Your Ref: OWPC25835
Our Ref: LU/36/20/HH 01-02-2020
Please ask for:
Zac Denton

Loft conversion with rear dormers.
2 Etherington Place Littlehampton

Proposed Elevations

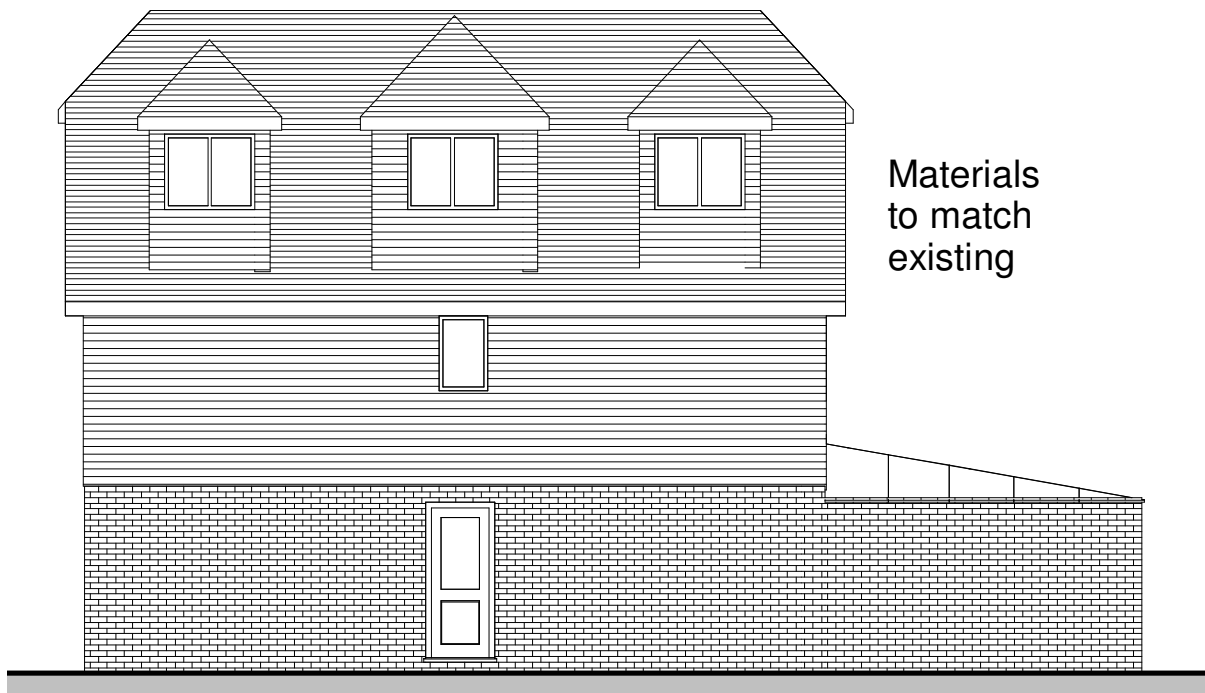
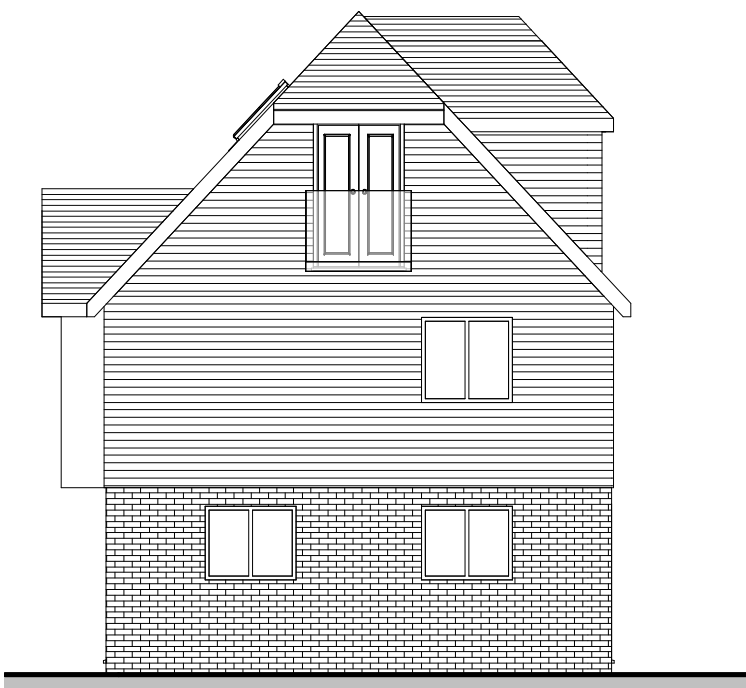
I will not register an objection myself as I do not live in the estate. However I was involved for a time in planning matters relating to this new estate which I believe has been designed to a very high standard and, in the main, has many features of planning excellence. I would ask the planning officer to look carefully to ensure that plans are not approved that are out of character, overbearing and will set a precedent. These do not look right to me.
